Planning Reference: LU/92/18/PL

Description: Studio apartment with roof extension & bin store & cycle store.

We are writing to you to object to the revised application at 126 Arundel Road due to our concern regarding the space being provided within the proposed studio apartment.

1210/P021 B

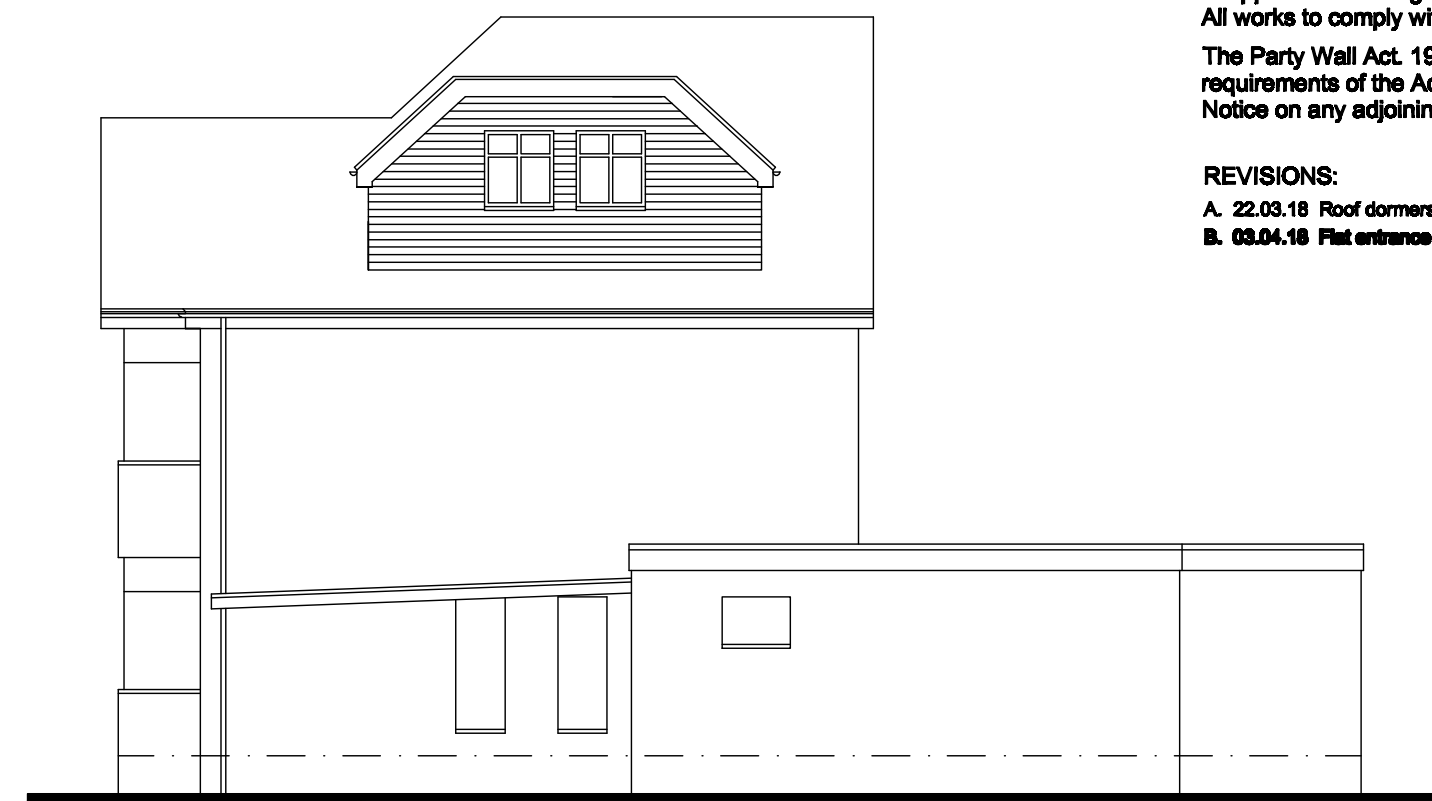
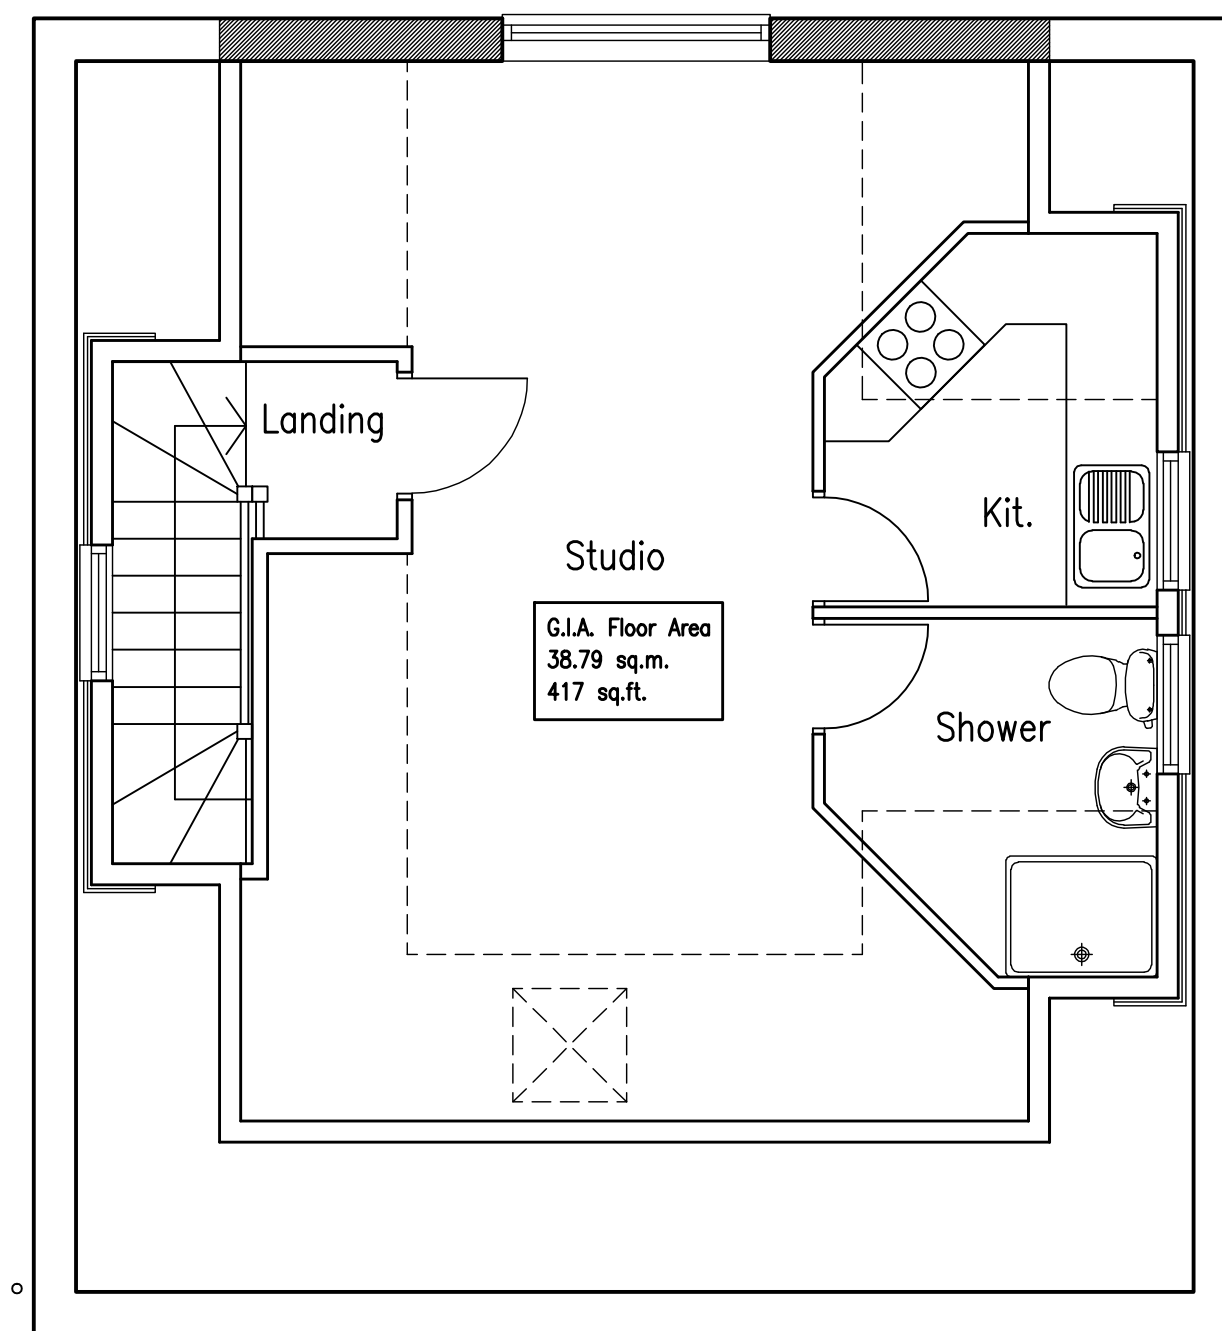
The plans provided state that the proposed studio flat is 38.79m² in area but this is measured to the low wall within the roof slope. The Department for communities and Local Government Technical Housing Standards states that are with a headroom of less than 1.5m should not be counted within the floor area of the flat.

The applicant has only provided plans and elevations for this development so there is no way to determine where this area has been measured from on the plans.

We have overlaid on these drawings red lines showing where the floor finish and roof slope finishes will be which has determined the 1.5m zone. This shows that the actual area should be measured at 32.9m² following the RICS and national space standards code for measuring. Also there isn't the allocated 1m² of storage space shown on the layout which is stipulated in the space standards.

The build-ups used are rough estimates of what will be required for structural and building control sign-off if the development reaches the next stage. We have also taken first floor ceiling height as being at window head which doesn't appear to be the case with most of the properties on Arundel road. If this line moves up then this will again reduce the area of the 1 bed 1 person studio.

We feel that the applicant should be requested to provide more information in the form of planning sections to show how the area has been calculated and then these should be re-consulted upon.
